Application no: H22/0717/97

Description: Erect detached dwelling with
detached garage (Plot 1)

Location: Oakleigh House, High Road
Weston
Spalding
Lincs

Amendment: Increase in size of detached garage
Dwg Nos. 970605/P2A and 95014/001F

DRAWING No. 970605 / P2

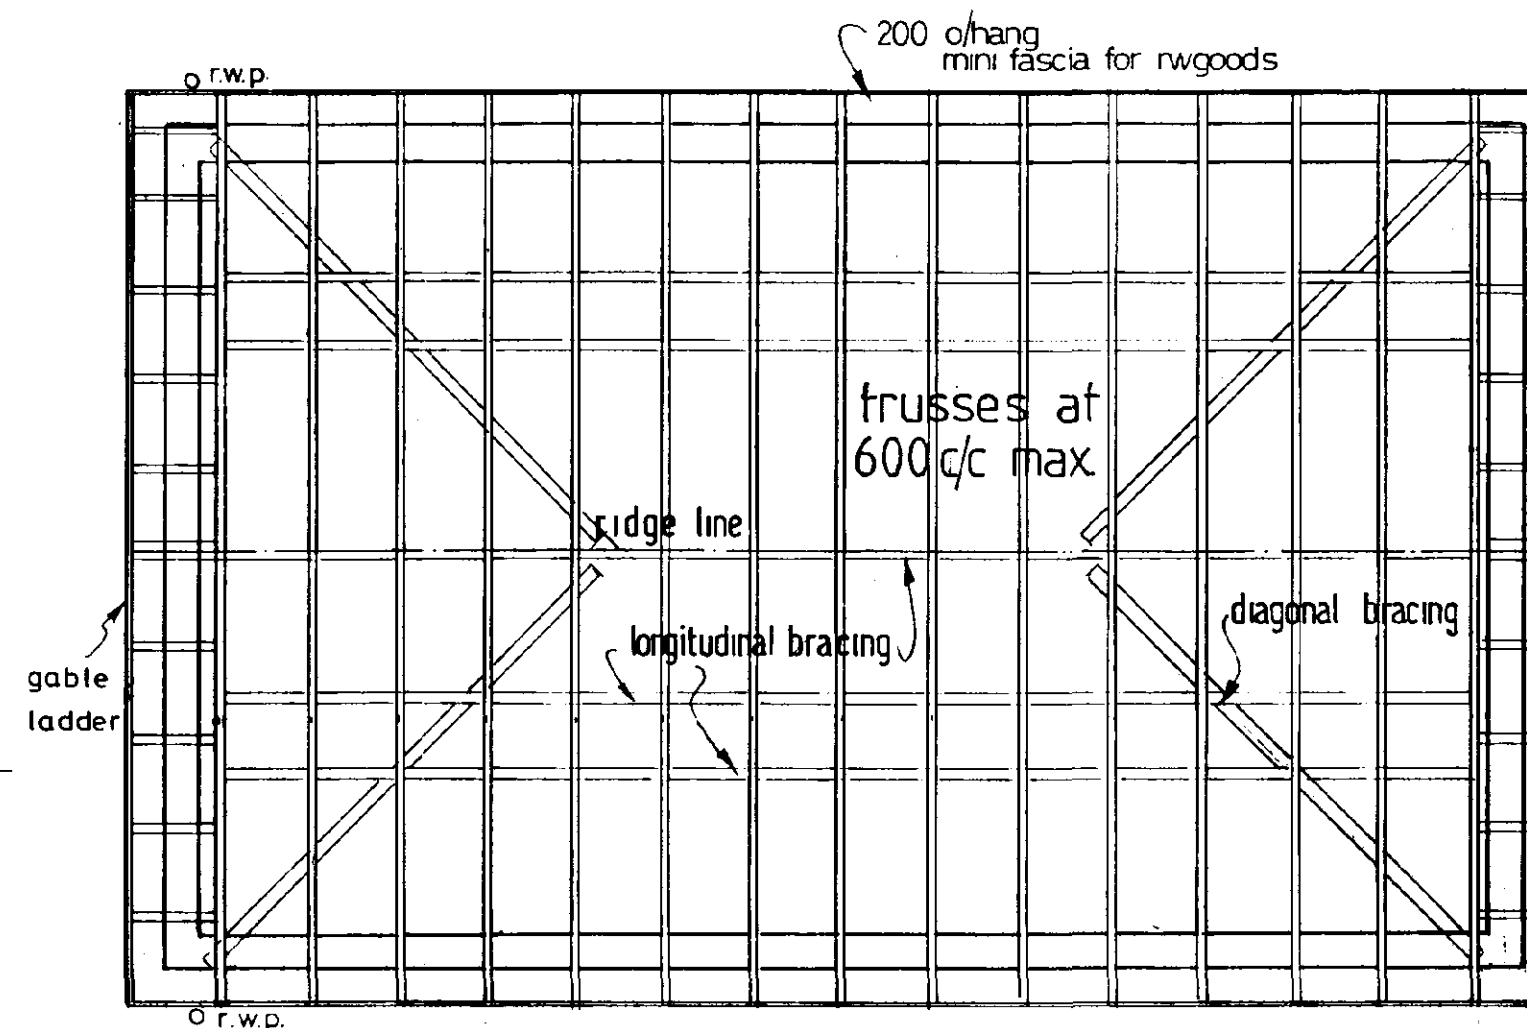
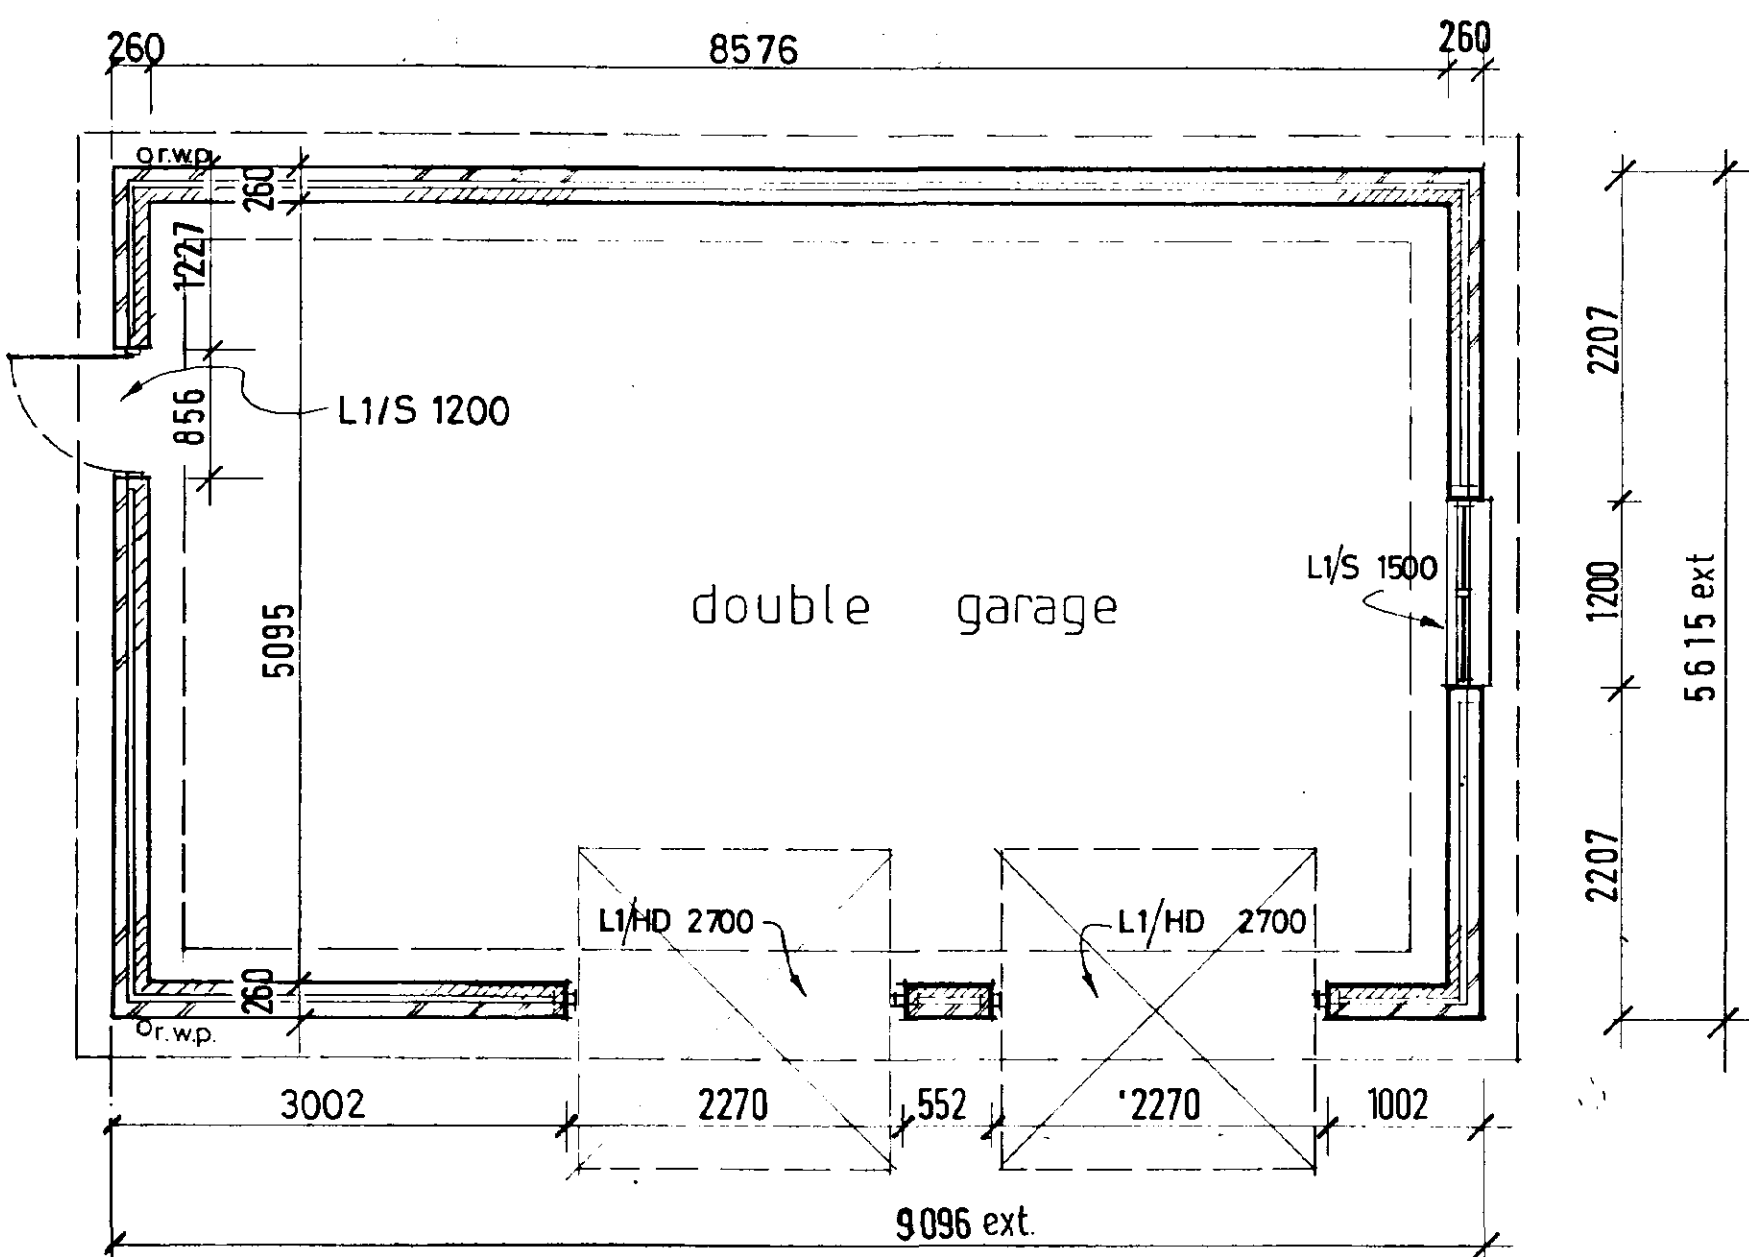
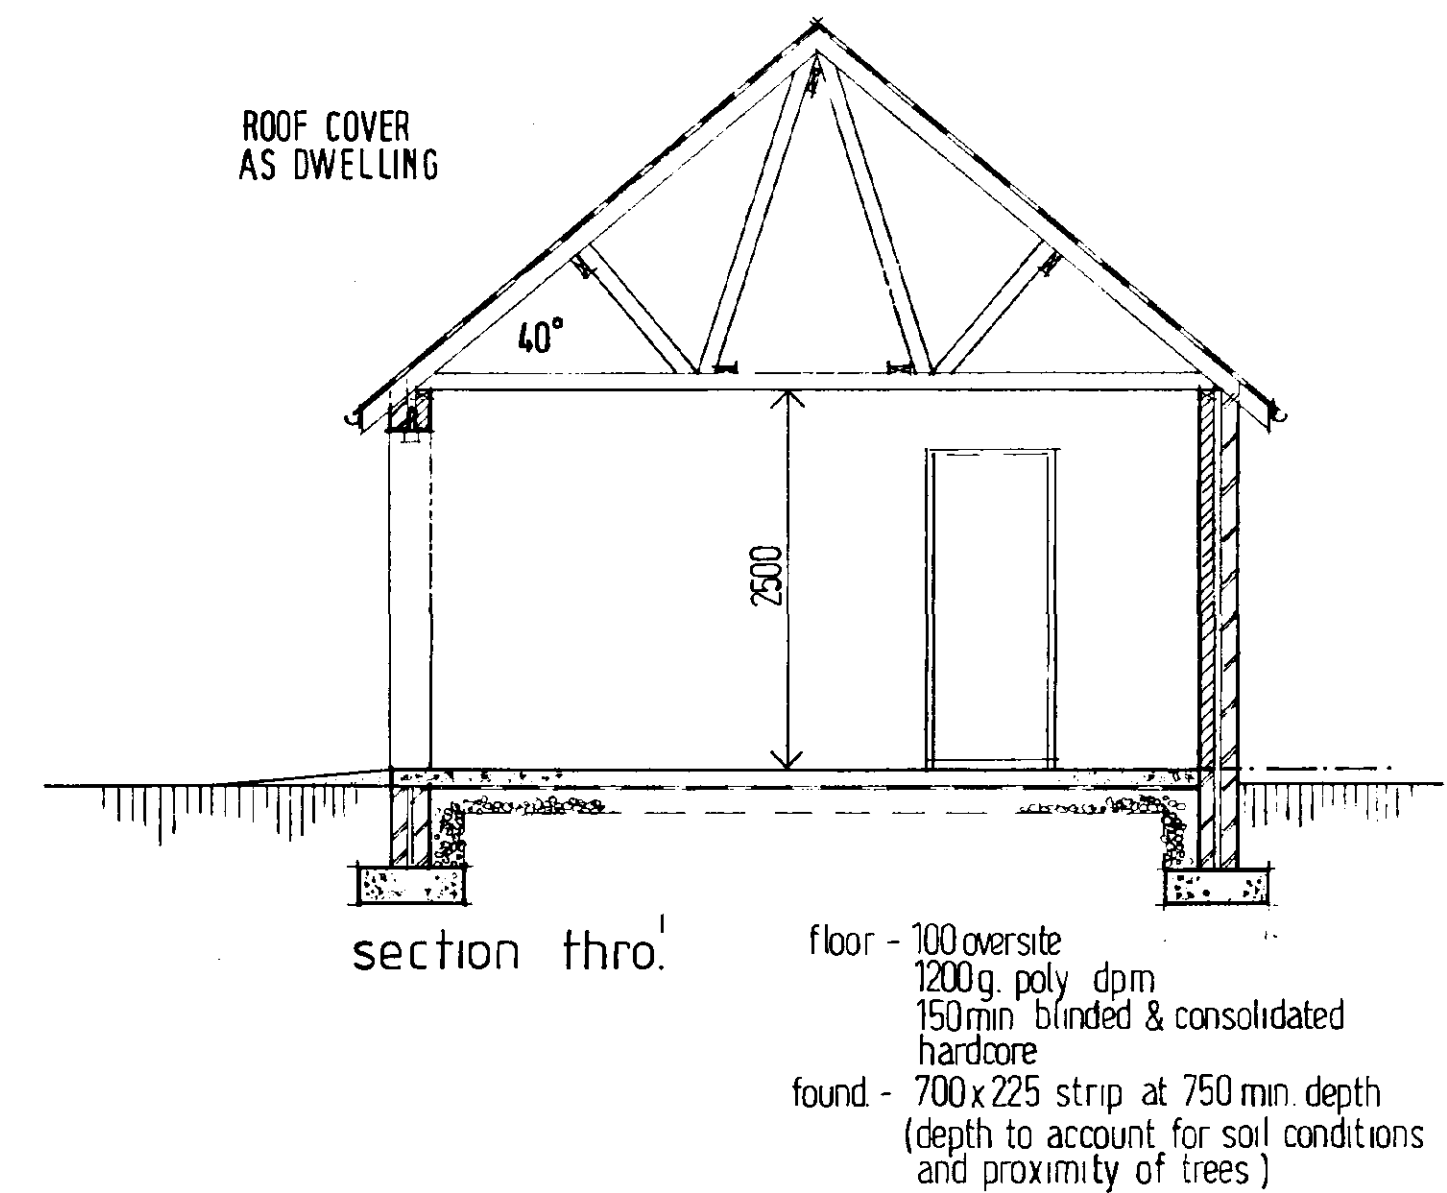
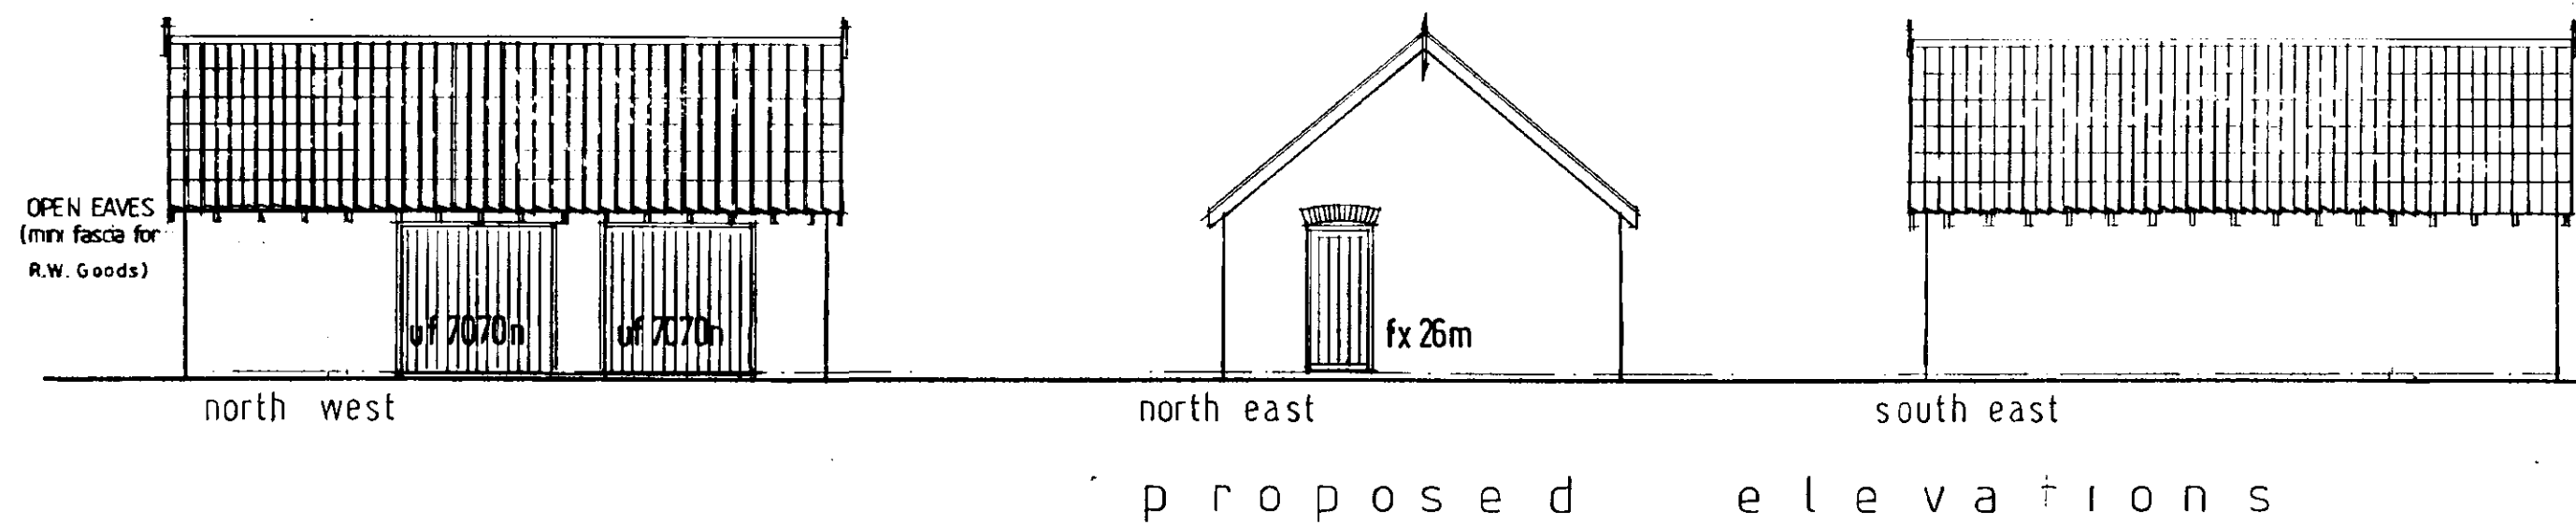
SIZE OF DETACHED GARAGE ALREADY
INCREASED BY 2.000M TO 9.096 0/10 W.

The amended details submitted in respect of the above proposal have now been considered, and I am able to inform you that there are no objections to the amendment being implemented to the extent described above.
